**City of Portland, Maine – Building or Use Permit Application** 389 Congress Street, 04101, Tel: (207) 874-8703, FAX: 874-8716

Location of Construction: 10 Exchange Street 04101		Owner: Joe Soley		Phone: 874-7000		Permit No: 000025	
Owner Address: P.O. Box 367, Portland, ME 04112		Lessee/Buyer's Name: N/A		Phone: N/A		Business Name: N/A	
Contractor Name: Joe Soley		Address: N/A		Phone: N/A		Permit Issued: JAN 12 2000 CITY OF PORTLAND	
Past Use: Retail		Proposed Use: Same		COST OF WORK: \$ 2,000		PERMIT FEE: \$ 36.00	
Proposed Project Description: Remove portion of floor & non-load bearing wall. Install stair and fire proof separation.				FIRE DEPT. <input type="checkbox"/> Approved <input type="checkbox"/> Denied		INSPECTION: Use Group: M Type: 3B BOCA 196	
				Signature:		Signature: <i>Hoffman</i>	
Permit Taken By: UVA				Date Applied For: 1-10-00			
PEDESTRIAN ACTIVITIES DISTRICT (P.A.D.)				Action: <input type="checkbox"/> Approved <input type="checkbox"/> Approved with Conditions <input type="checkbox"/> Denied			
Signature:				Date:

**CITY OF PORTLAND**  
**STOP WORK NOTICE**

Re 10 Exchange Street - Portland, Maine  
Building Permit #032-1-12

TO EXCHANGE ST.
INTERCOMMUNICATING STAIR

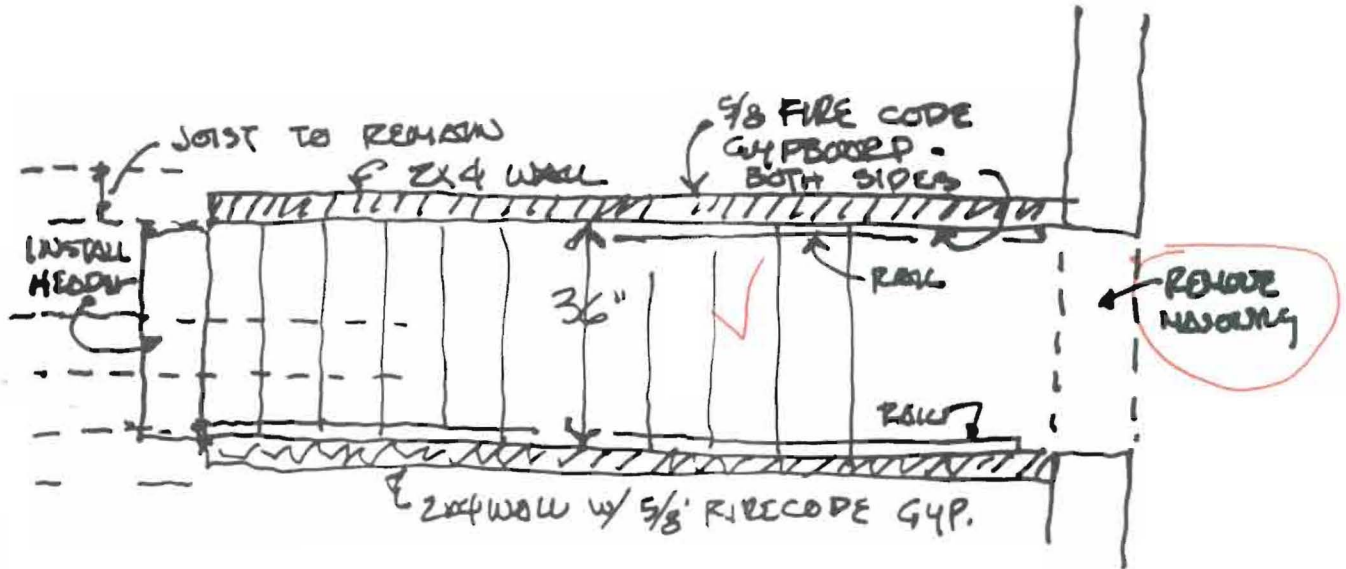
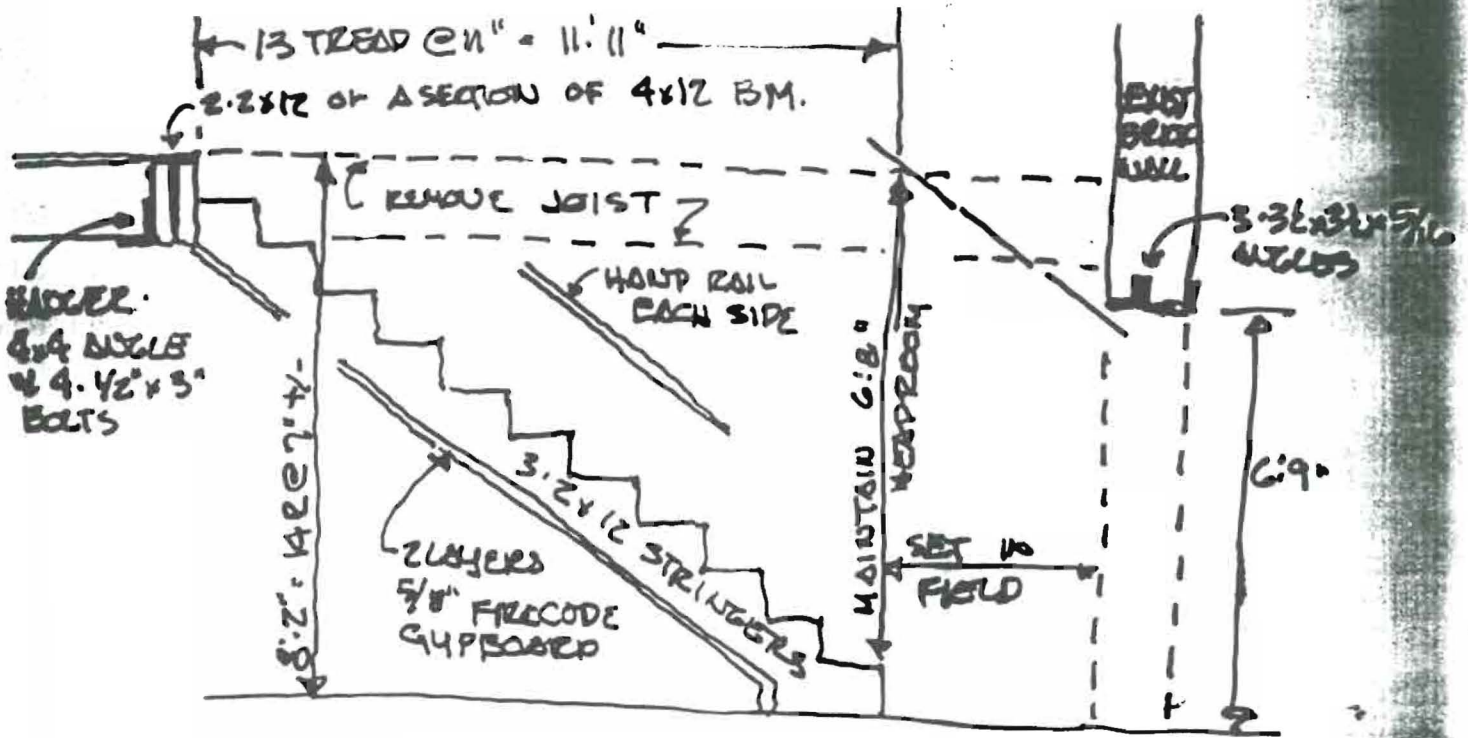
2-17-00 An inspection determined The wall was Load Bearing - issued a Stop Work Order - need further ammendment to continue. JB

Also speak to contractor about 7"x11" Rise/Run & minimum 36" width of opening JB

The permit was issued for a penetration in a "Non-loadbearing" wall . On site inspection revealed that the wall is loadbearing.

I am including a revised plan of the proposed stair at the Hemp Shop at #10 Exchange street. As you know the previous stair was declared to be too narrow (25") to meet the 35" code requirement.

The present proposal is for a spiral intercommunicating stair which meets the requirements of (BOCA 1014.6 and figure 1014.6.4) for spiral stairs.

The code states that the stair cannot be used as a means of egress, and as it does not serve as a means of egress it should be OK. The code states that "like stairways with winders, spiral stairs may be used in any occupancy as long as such stairs are not a component of a required means of egress." Also the winders section (1040.6.3) also states "This section does not prohibit winders (and by the reference mentioned above spiral stairs) from being used in stairways that are not a required means of egress."

We have also shown the horizontal opening through the brick wall to be 36" wide and the entire 36" is below the arch above therefore carrying no wall load. The joists interrupted will be carried by the new wall build to close off the stair area from the adjacent shop.
